PROJECT # 1002357  
**M-15 / D 39**

PROJECT TITLE: RNG, LLC, OFFICE/SHOP ZONE MAP/DRG. FILE #: M-15 / D 39  
DRB #: 03 DRB. 00287 (SOP) PC#: 02876 - 01767 WORK ORDER#:

LEGAL DESCRIPTION: LOT 11, N2 COMMERCIAL OFFICE CENTER  
CITY ADDRESS: 1710 RANDOLPH COURT S.E.

LOT 11
NZ COMMERCIAL OFFICE CENTER
1710 RANDOLPH CT SE
CONCEPTUAL GRADING, DRAINAGE & UTILITY PLAN

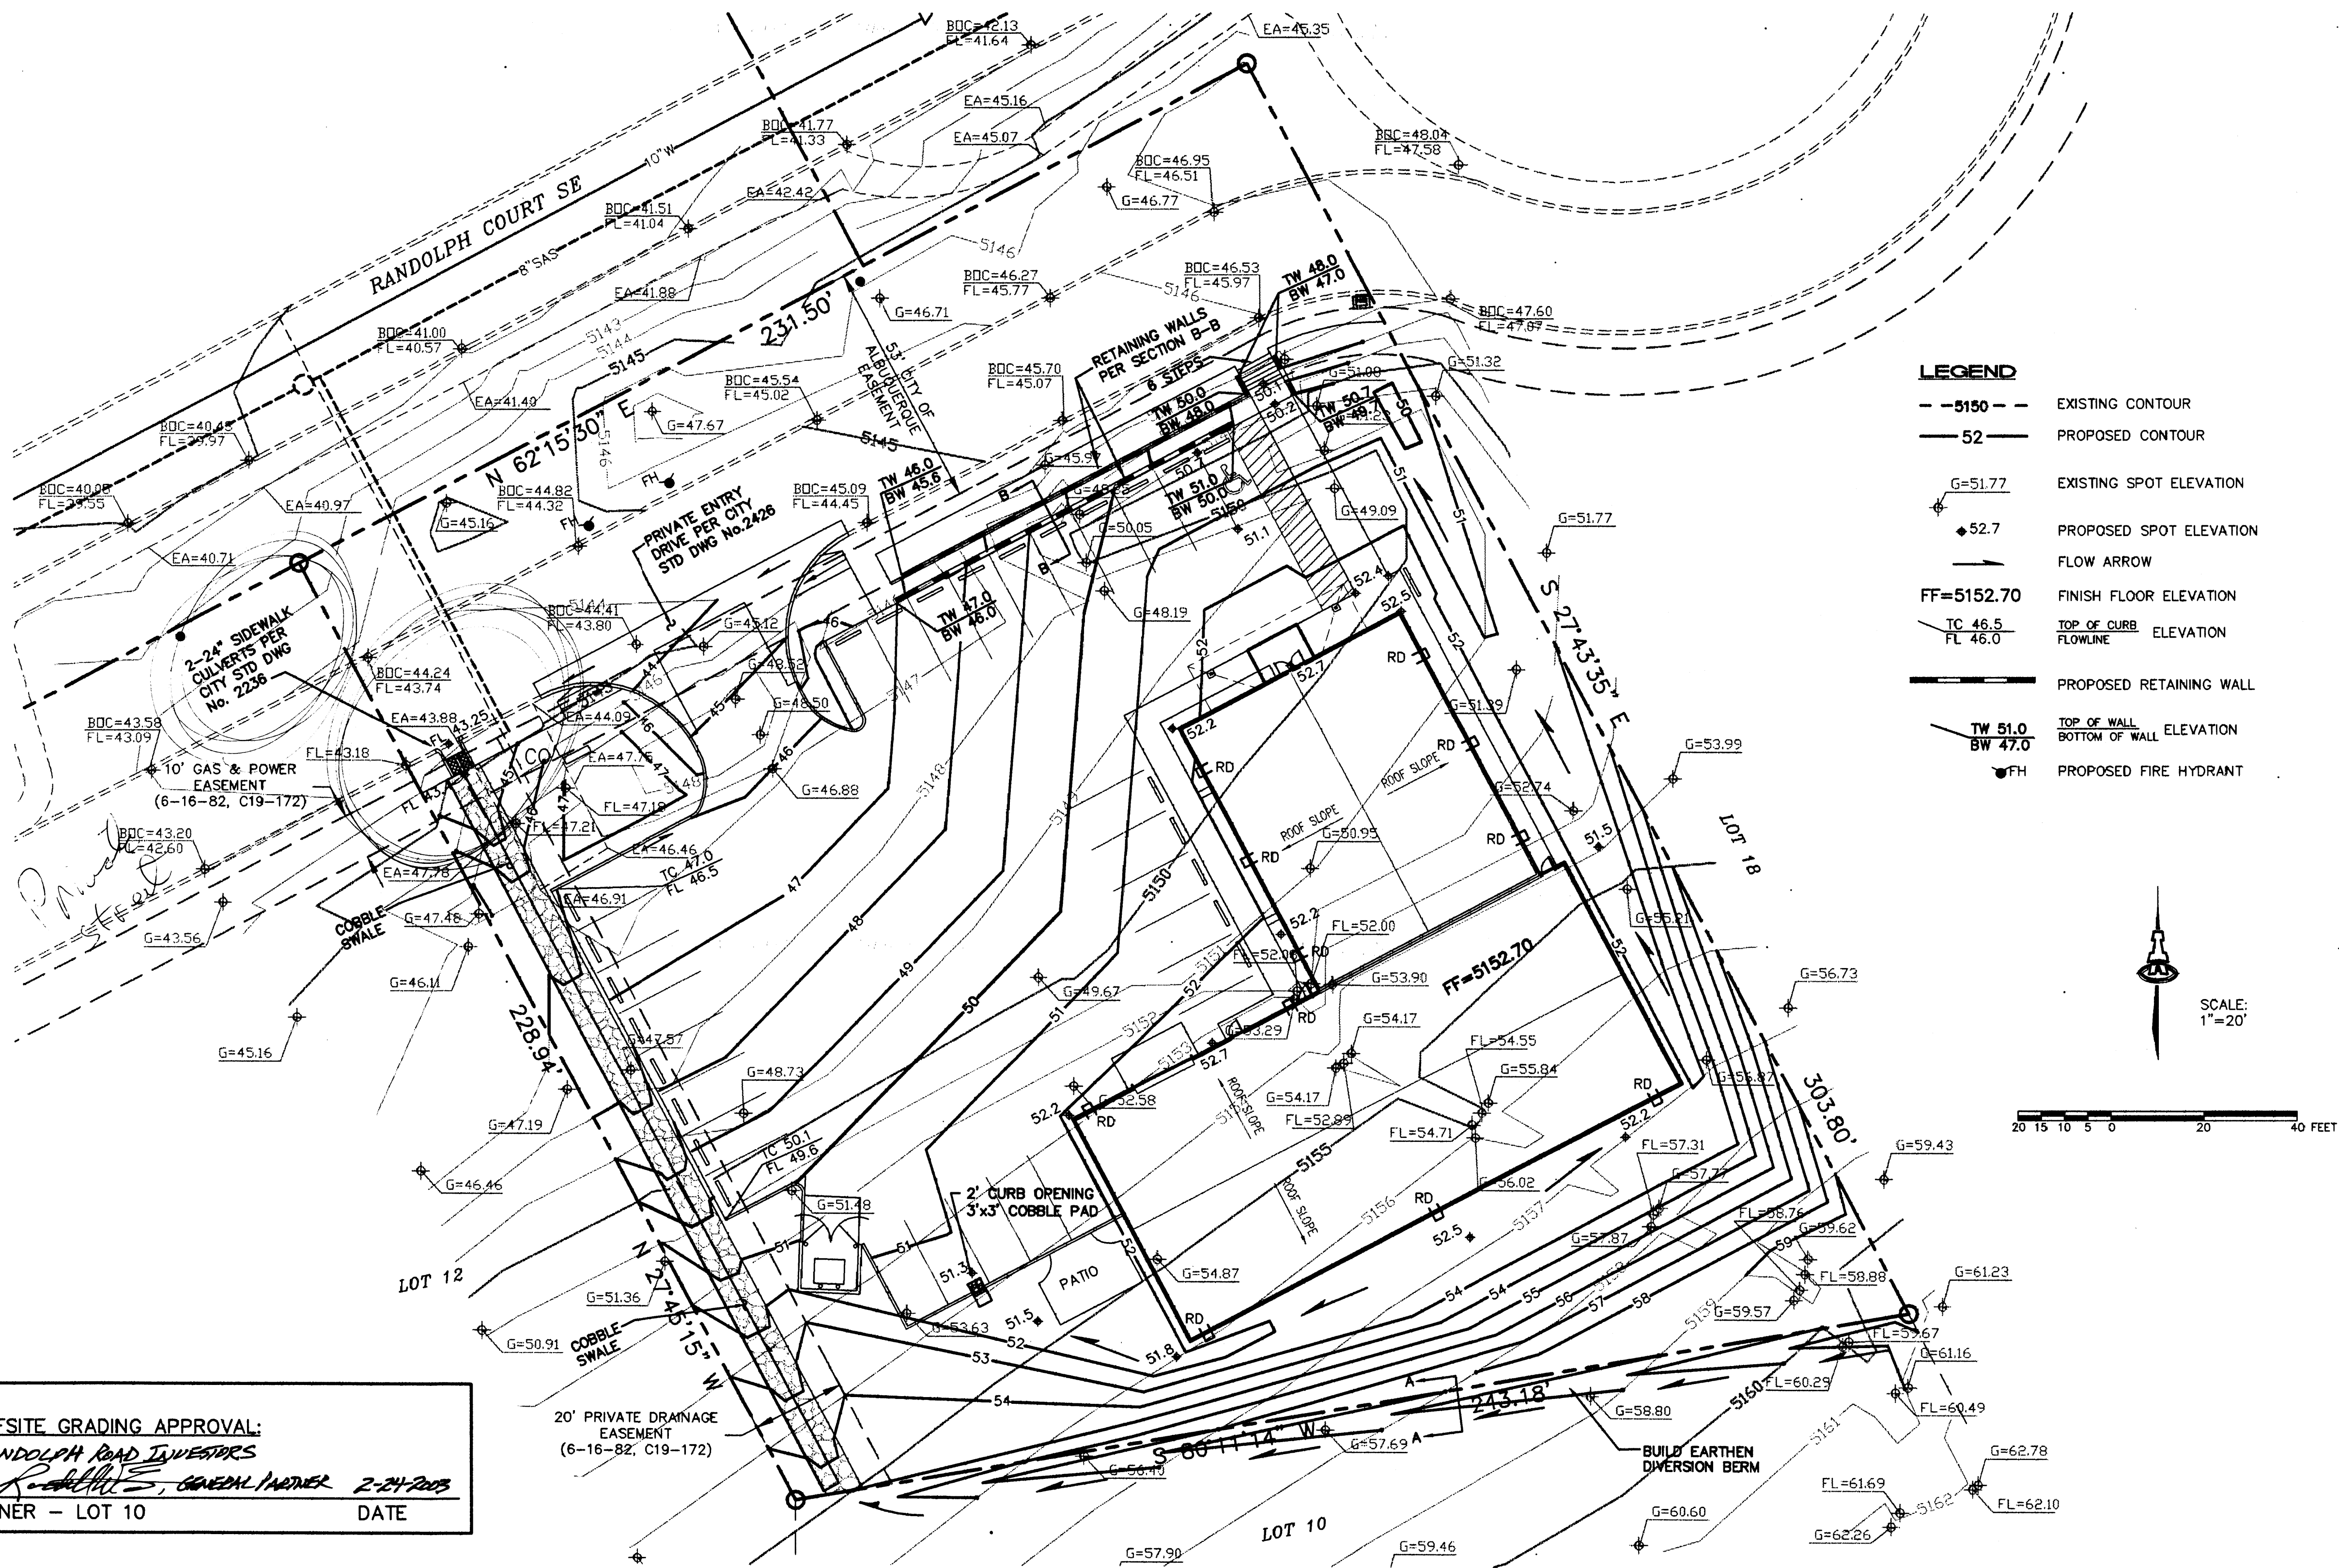
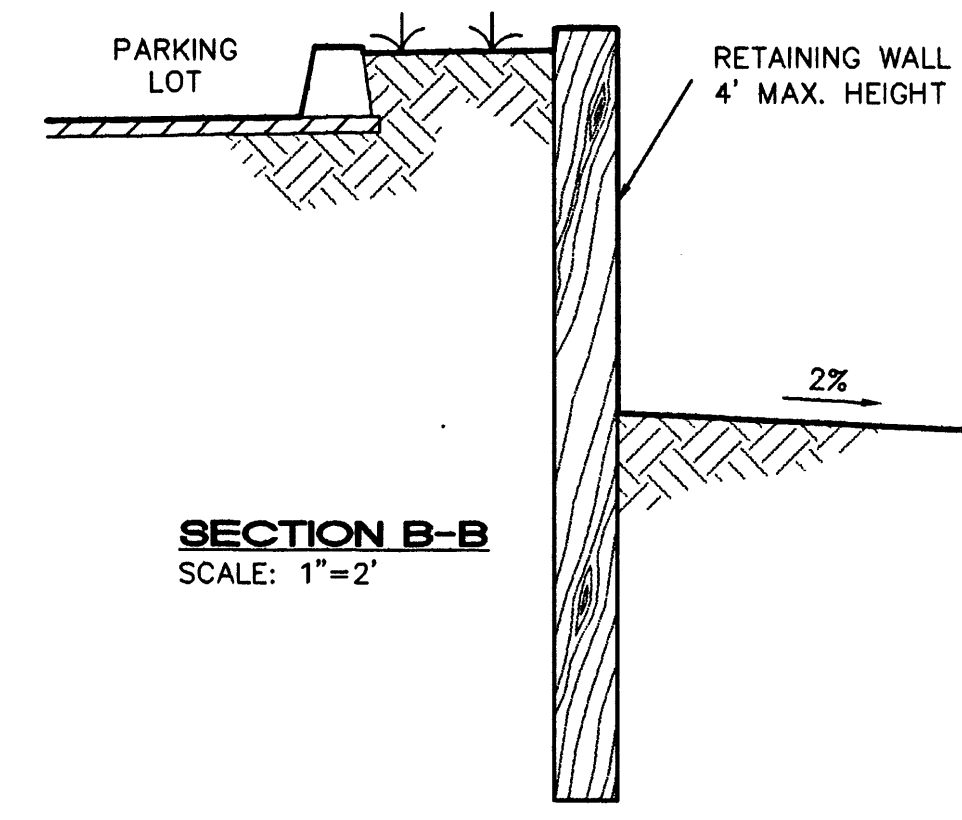
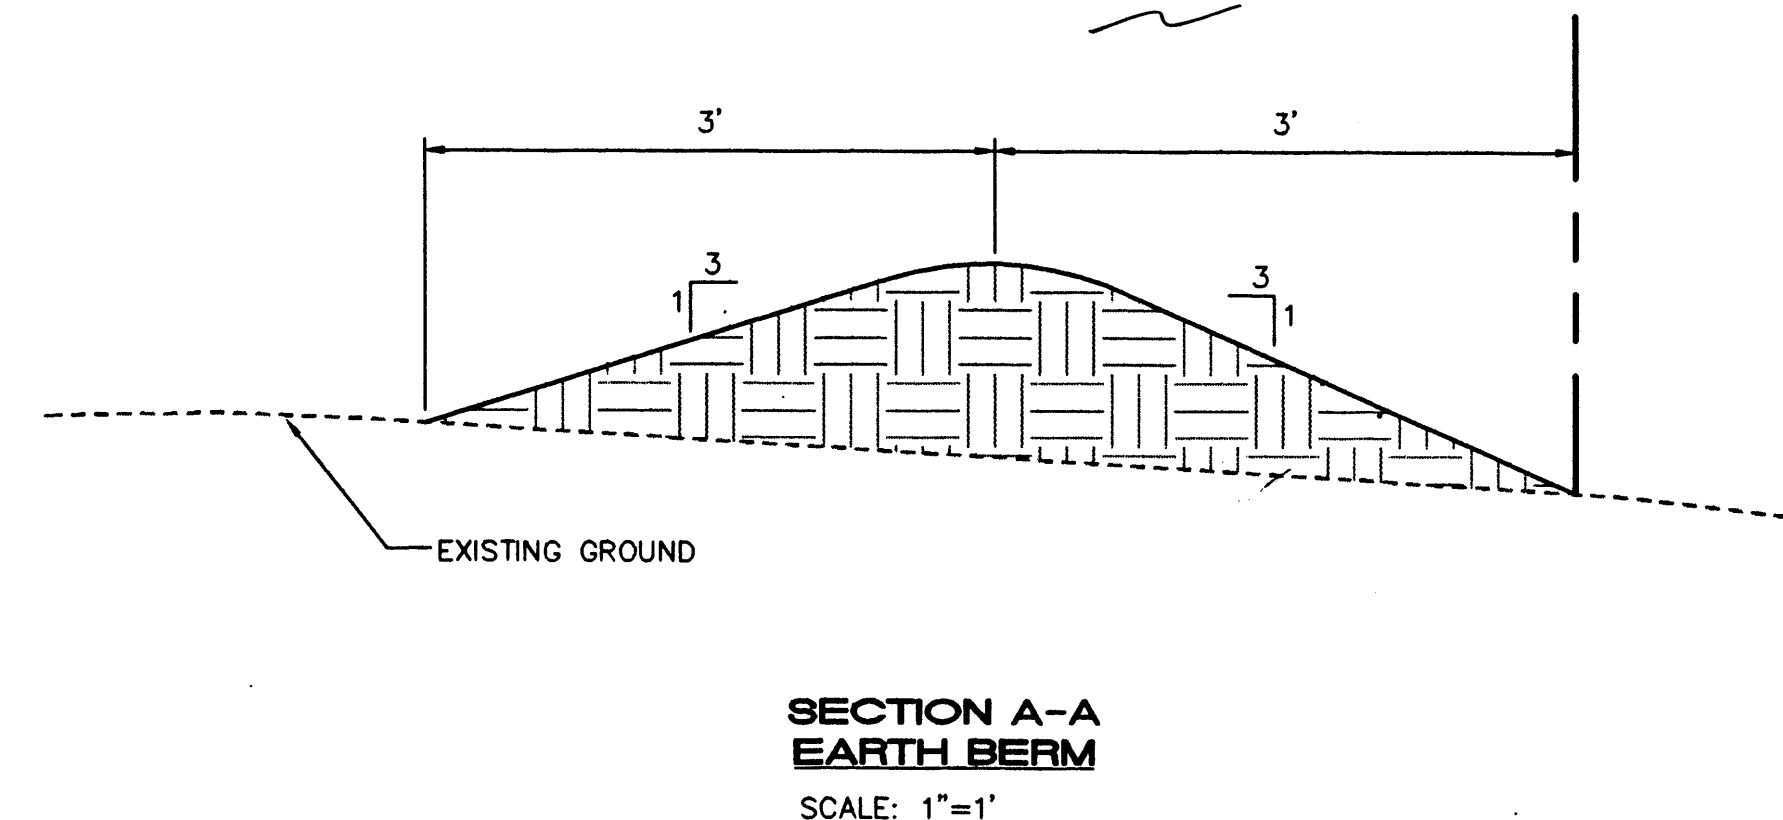
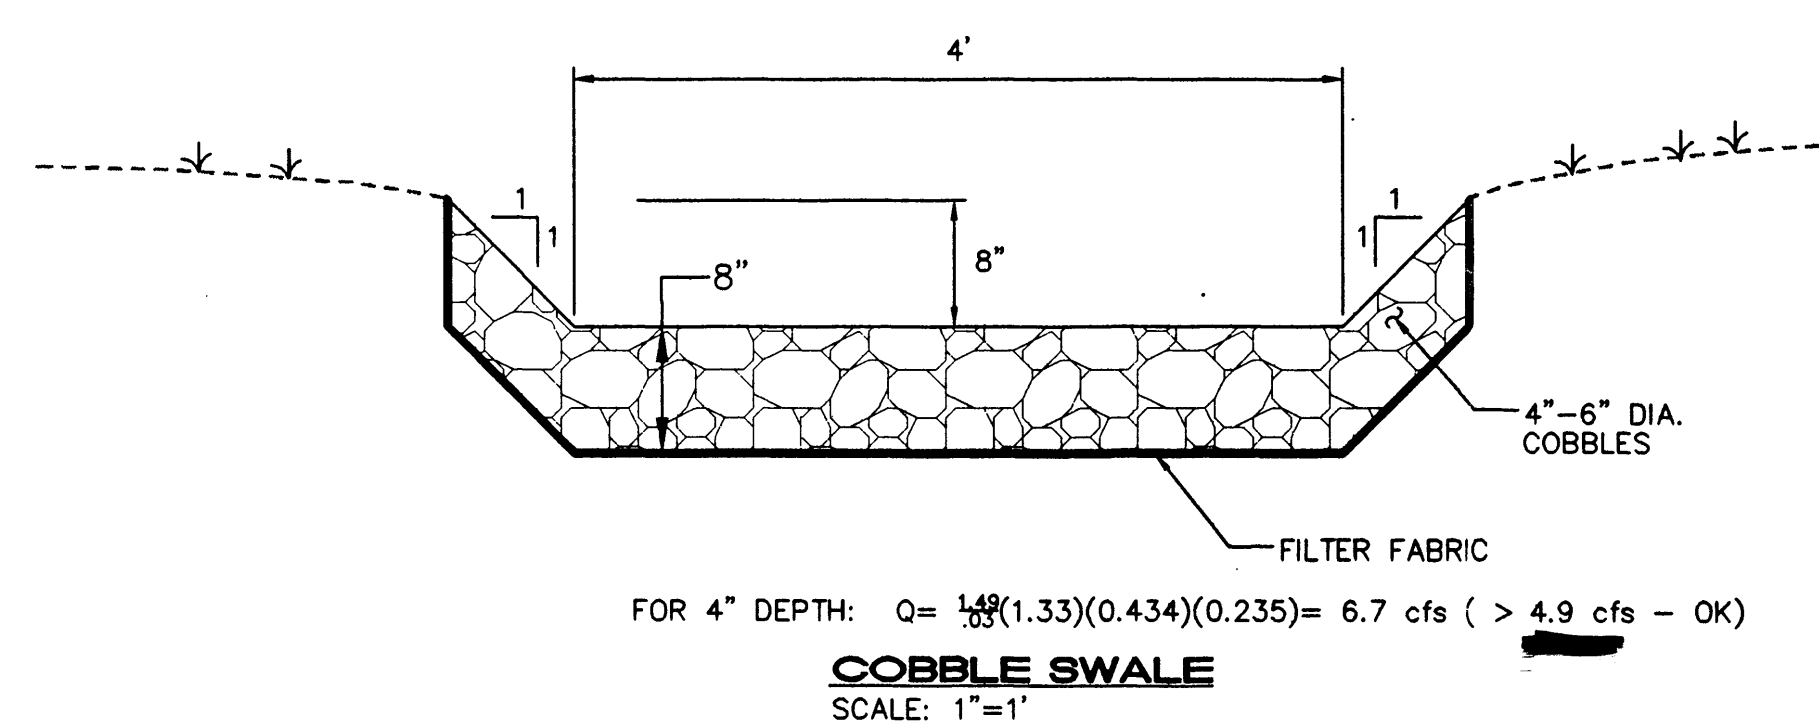
- Offsite grading requires permission of the owners of the property to be graded.
- Please provide offsite drainage basin.

Your review comments of 12/19/02 have been addressed with this resubmittal for Building Permit approval. The adjacent property owner has signed the plan allowing for grading on the adjacent Lot 10. An exhibit is also included to show the offsite basin (Lot 10). This exhibit is from the original grading plan prepared for this subdivision by Andrews, Asbury, and Robert in 1982. No grading appears to have been performed since that time.
